Please ask for: Nicola Moore
Email: nicola.moore@arun.gov.uk
Telephone: Ext 37944
Our Ref: FP/42/22/CLP
Your Ref:
Date: 17th March 2022

Lawful Development Certificate for a Proposed Use or Development

Development: Lawful development certificate for a proposed single storey rear extension and external & internal alterations.
Location: 38 Limmer Lane Felpham PO22 7EU

DRAWING	NUMBER
As Existing	202106.LP
Location and Block Plans	REVISION
	SCALE 1:1250 & 1:500 @A3
	DATE March 2022

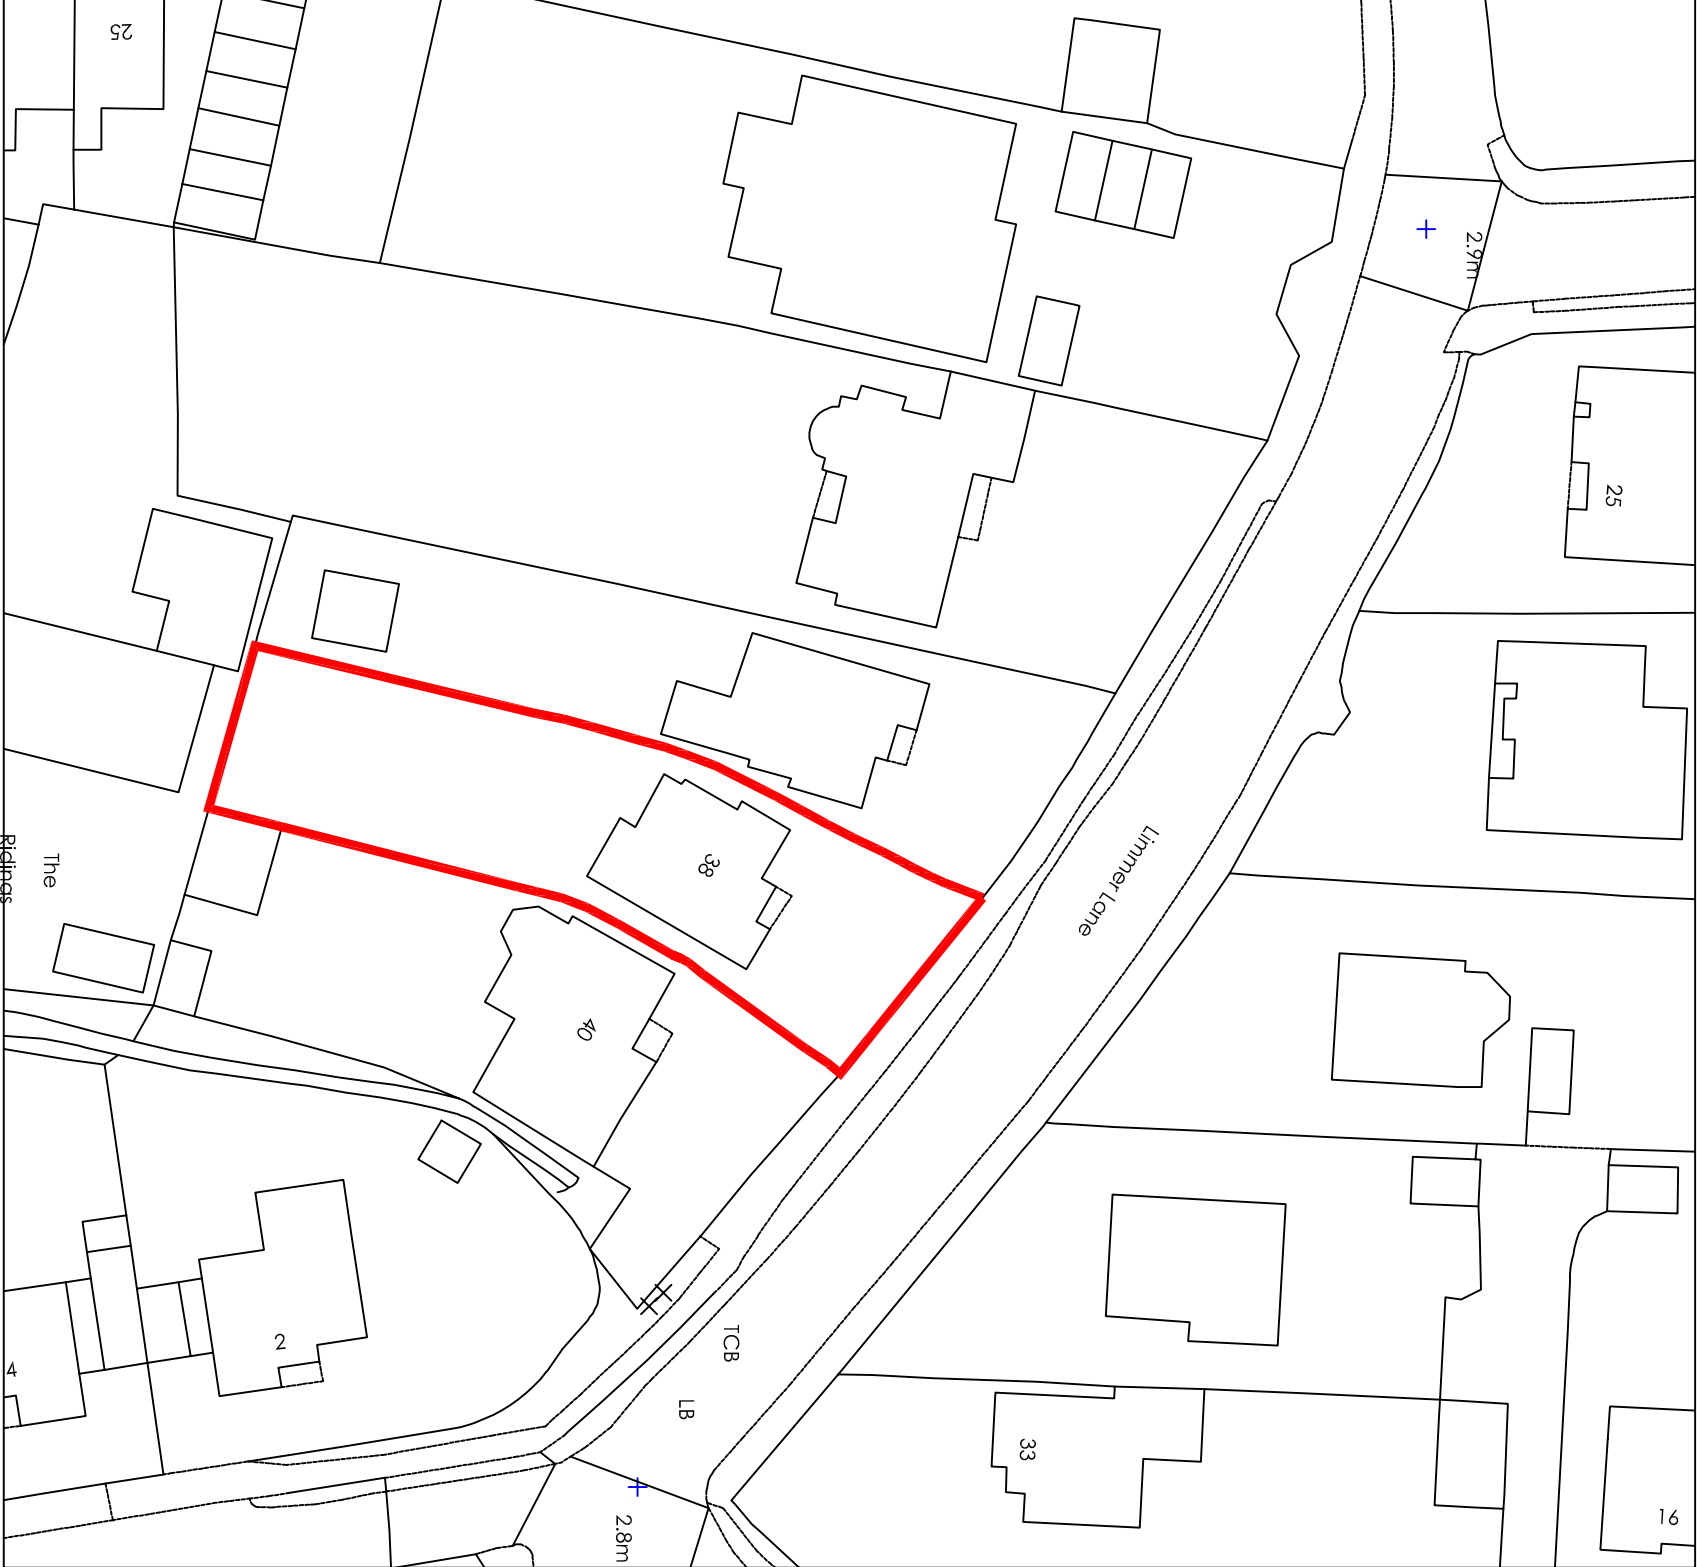
The Block plan should include distances to boundaries from the proposed development. Please amend accordingly and re submit.

DRAWING	NUMBER 202106.PAP 02
As Proposed	REVISION A
Floor plans	SCALE 1:100 @ A3
	DATE March 2022

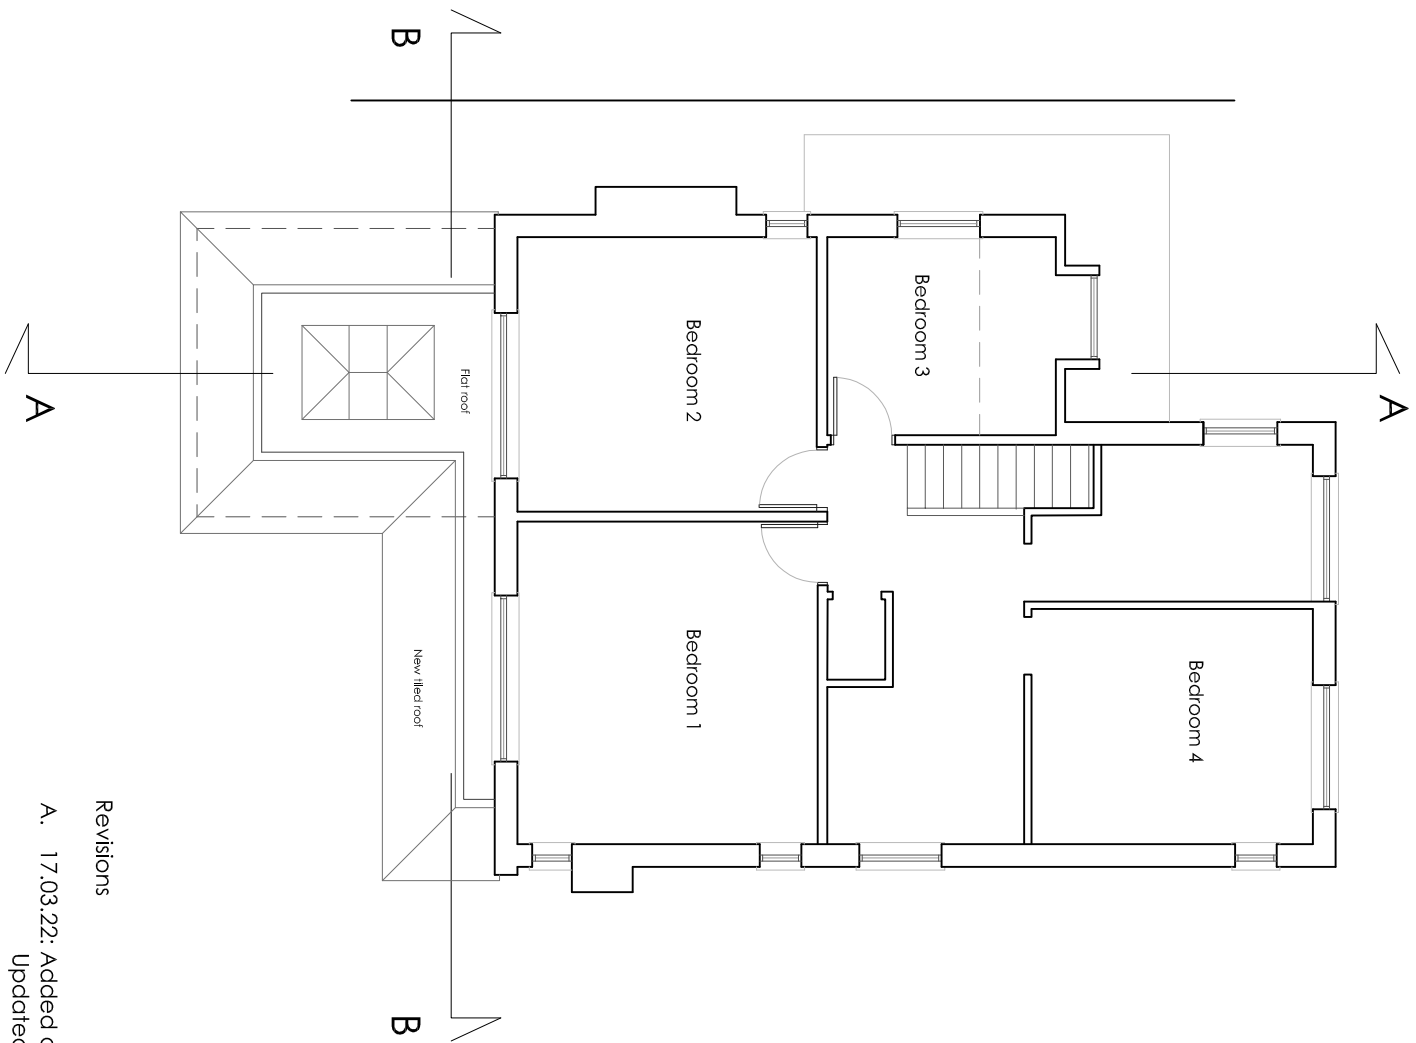
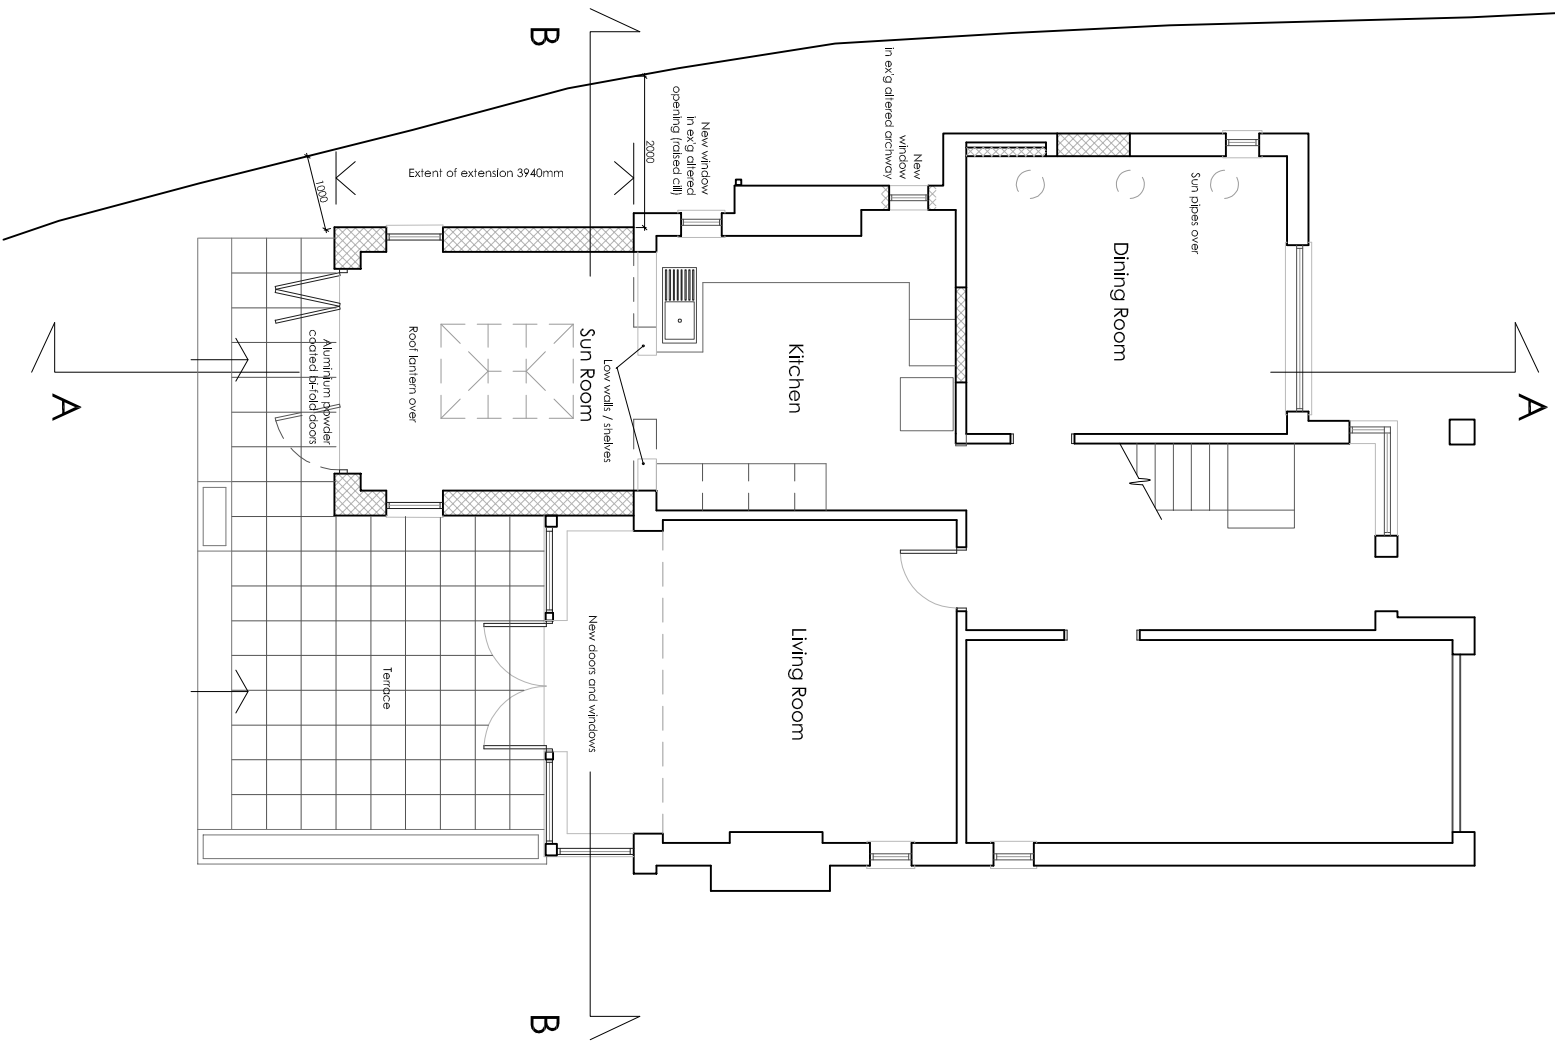
Please check the following measurements, amend accordingly and re submit:
Window NW and SE elevation of extension = 0.75m on elevation but 0.5m on floor.

New window in existing altered archway NW elevation = 0.5m on elevation but 0.8m on floor plan.
